December 16, 2022

**Re: Dispensary Central UNM**  
**110 Yale Blvd. SE**  
**30-Day Temporary Certificate of Occupancy**  
**Transportation Development Final Inspection**  
Architect's Stamp dated 07-20-22 (K15-D110)  
Certification dated 12-15-22

**G-003**

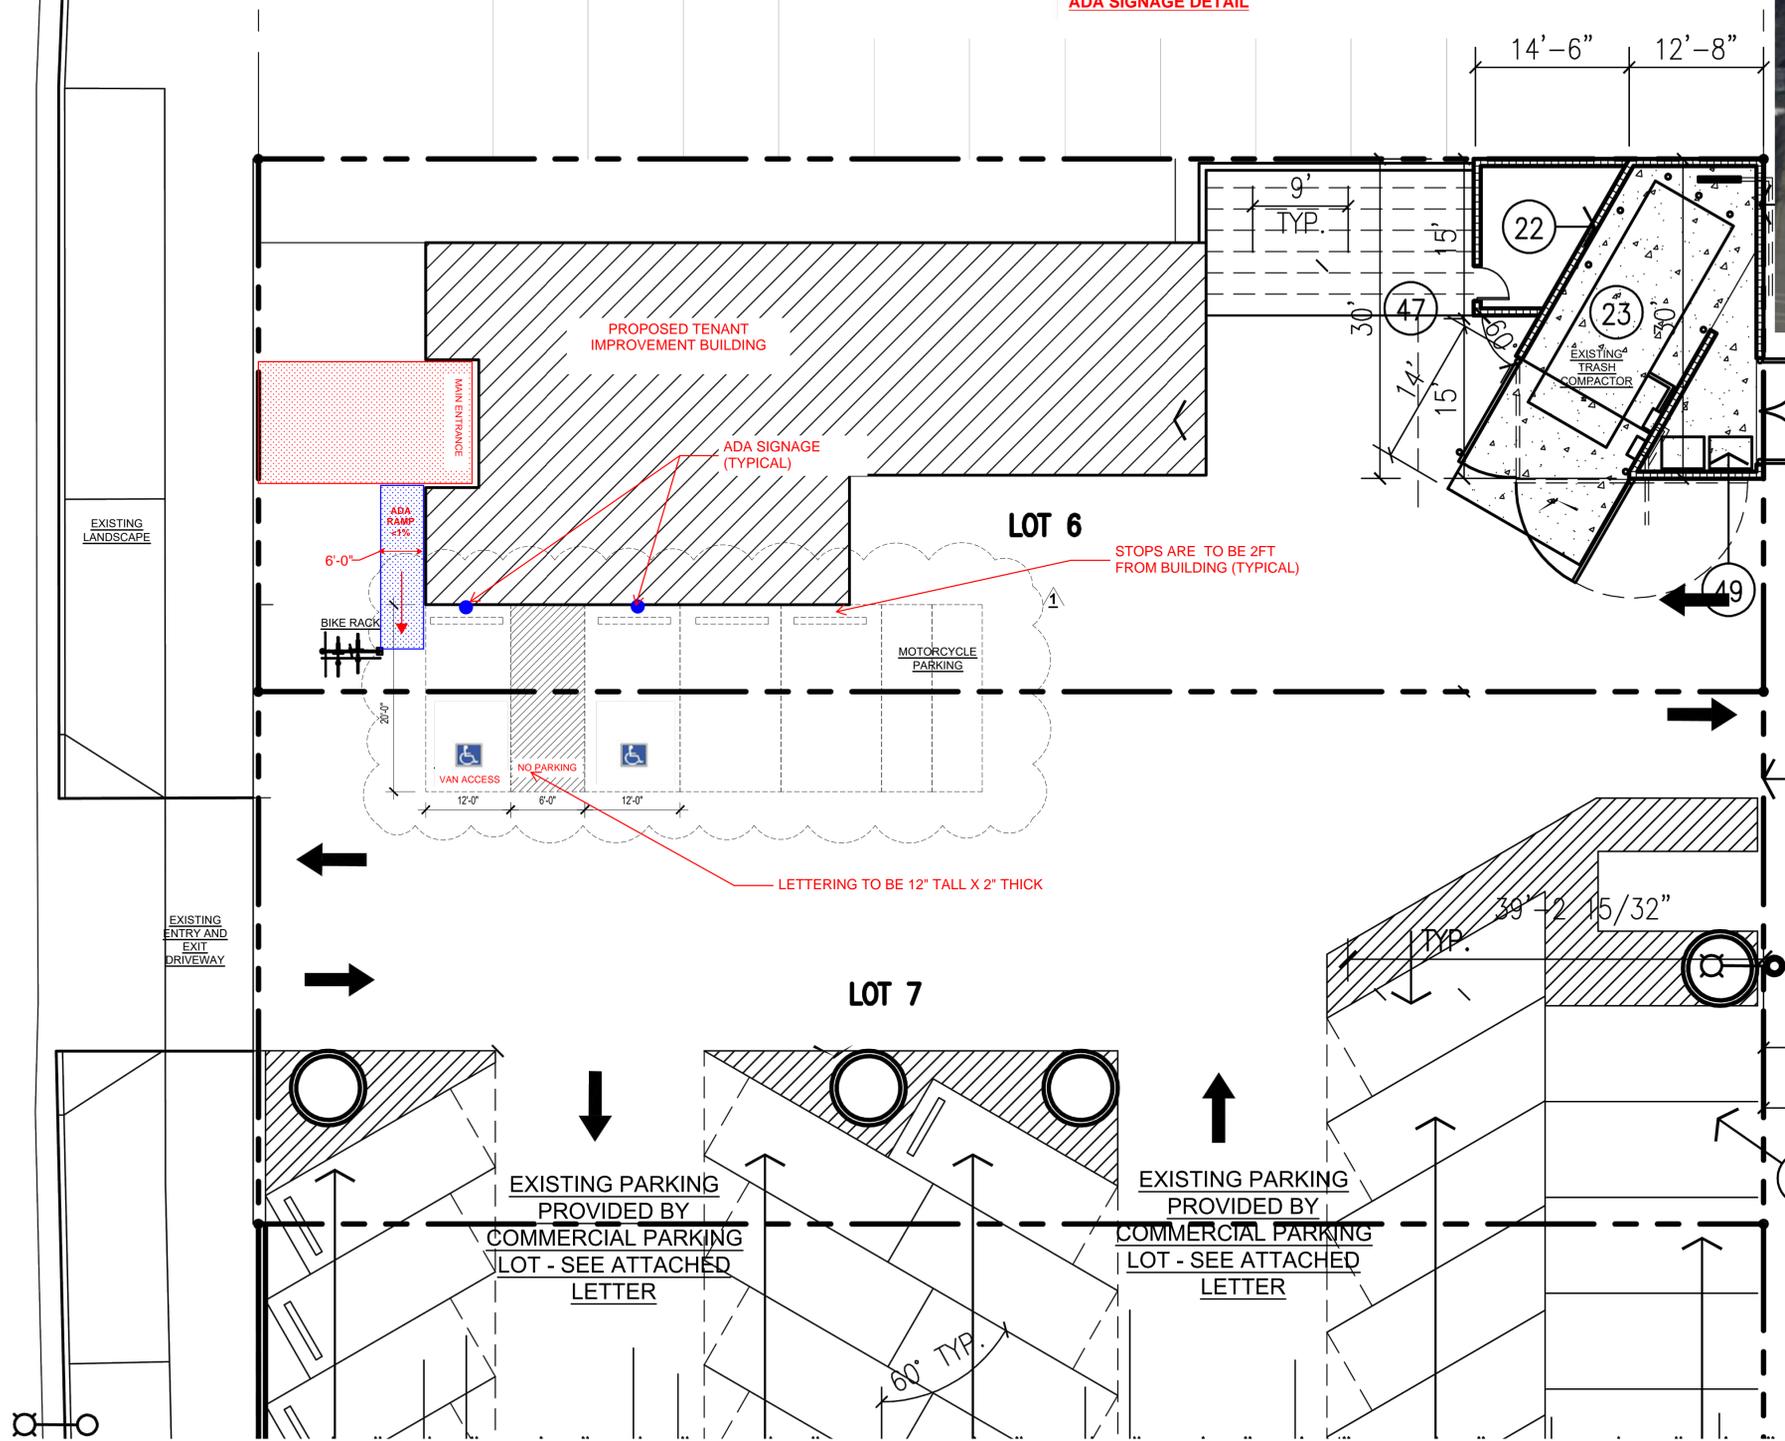
- The ADA accessible parking sign must have the required language per 66-7-352.4C NMSA 1978 "**Violators Are Subject to a Fine and/or Towing.**" Please call out detail and location of signs.
- Provide Motorcycle parking signs.
- Anchor down Bike rack
